CITY OF ALBUQUERQUE

Site: Fiesta Kia-7400 Lomas Blvd NE

Re: Drainage Ordinance (14-5-2-1) Violations for Erosion and Sediment Control

Stabilized Construction Entrance

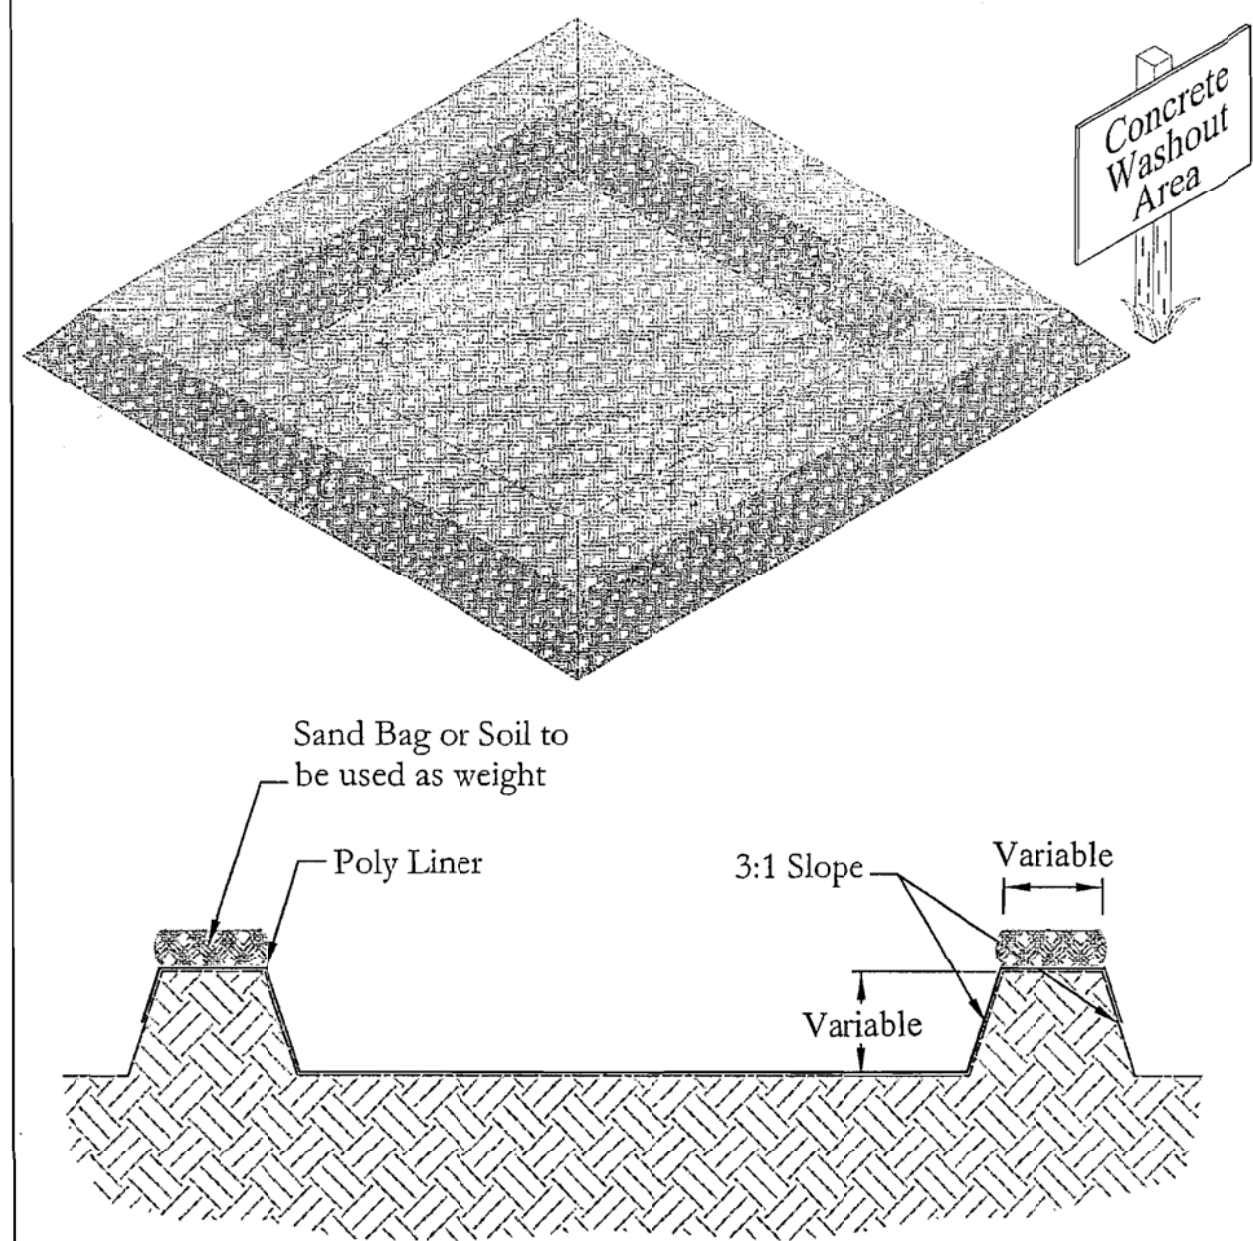
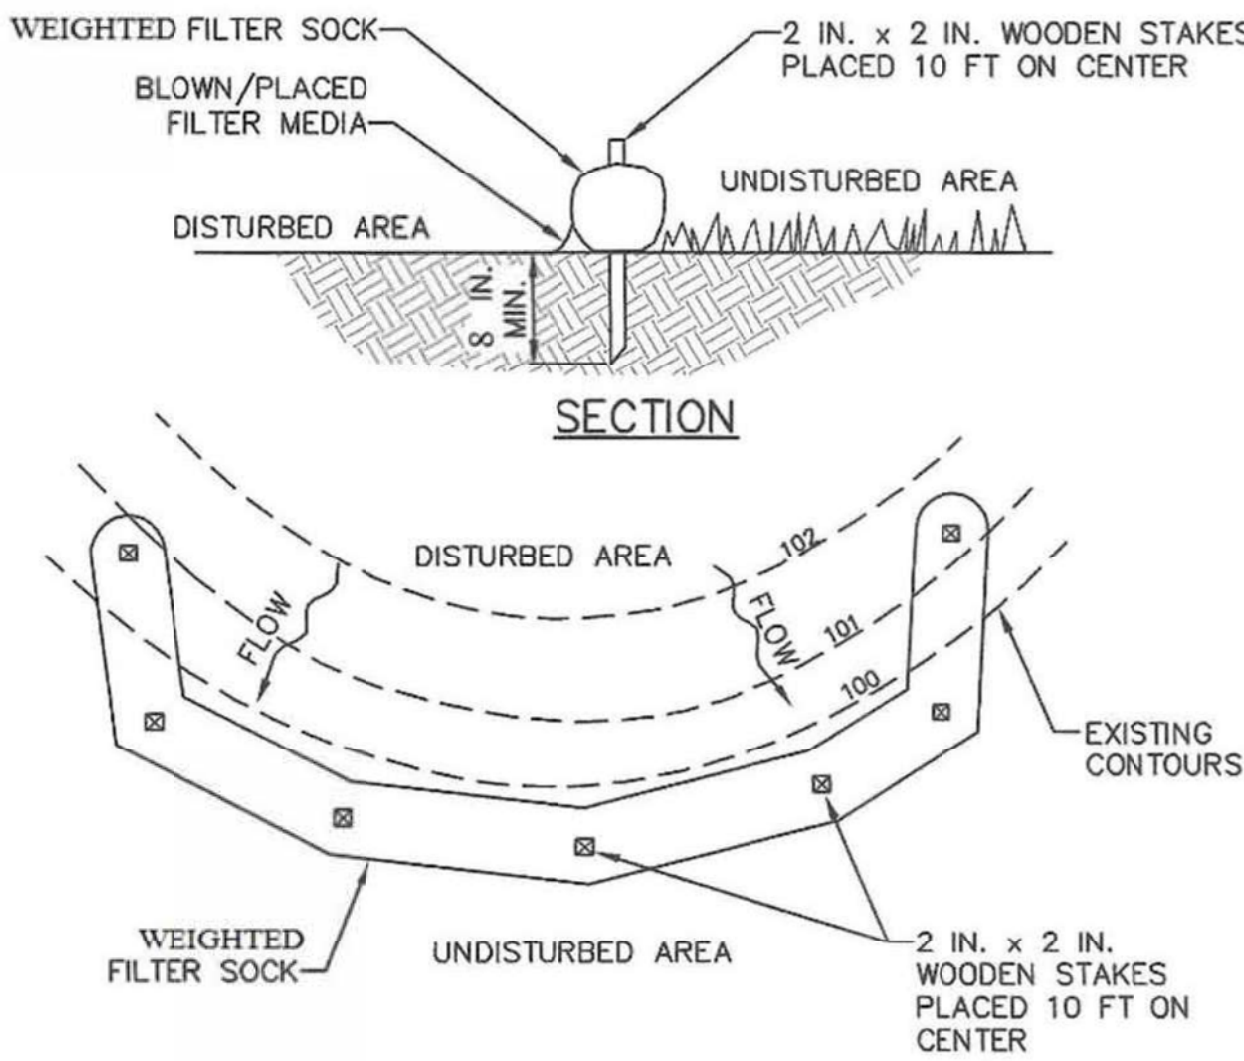
1. Workers exiting the site from a dirt/muddy area in two locations without a track-out pad.
2. Track-out onto Lomas Blvd.
3. Sediment from the site draining in gutter on Lomas Blvd.
4. Wash-out on the dirt.
5. The site was not posted per paragraph 1.5 of the NPDES CGP.

East exit with no track-out pad.

West exit with no track-out pad.

Muddy parking area. Mud being tracked off-site.

1. Provide Vehicle Tracking Control (track-out pad) for workers exiting the site from the north area or close area from vehicle traffic.
2. Remove sediment from Lomas Blvd (street and gutter). You may need a truck with lights or similar for traffic control.
3. Prevent sediment from entering Lomas Blvd in the future.
4. Remove the wash-out from the dirt and have workers use an acceptable wash-out facility in the future.
5. Post the site per paragraph 1.5 of the NPDES Construction General Permit.
